# ENG-SP20003-R5-PrelimPlan.pdf Markup Summary

### LANDSCAPE PLAN

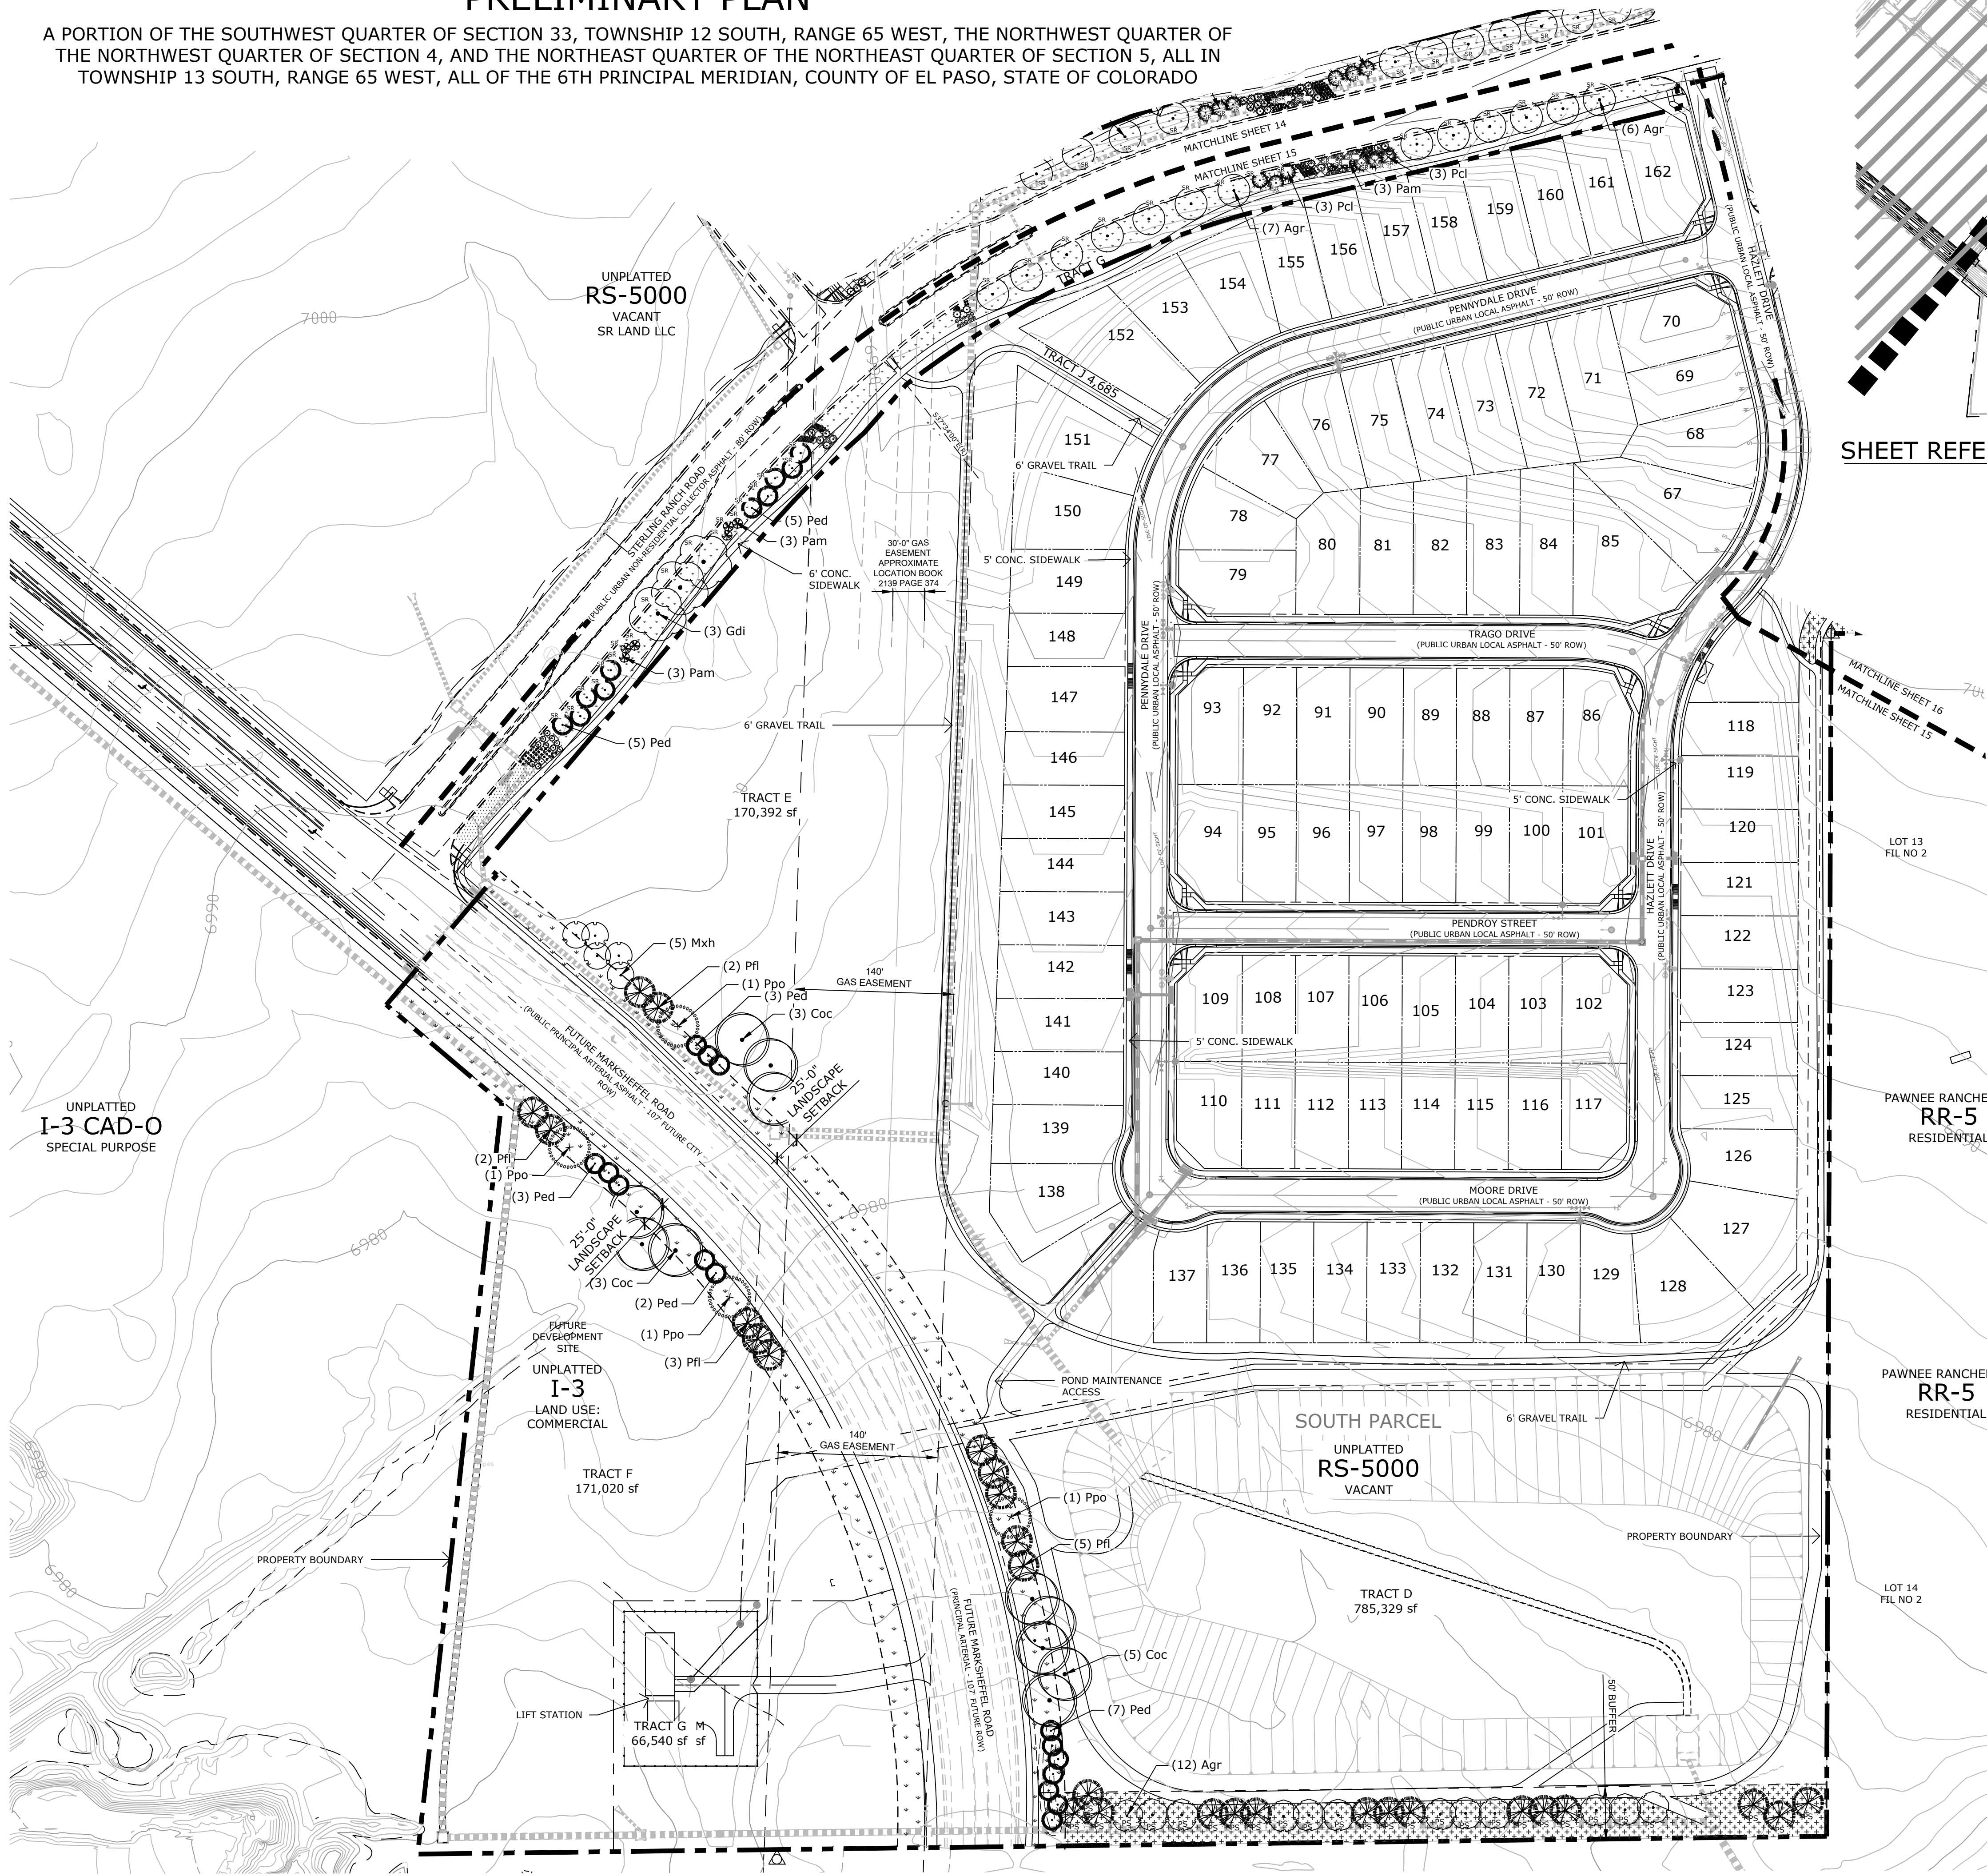
See comment letter

**RESPONSE:**  
Trees relocated  
outside Sterling  
Ranch & Mark  
Sheffel ROW
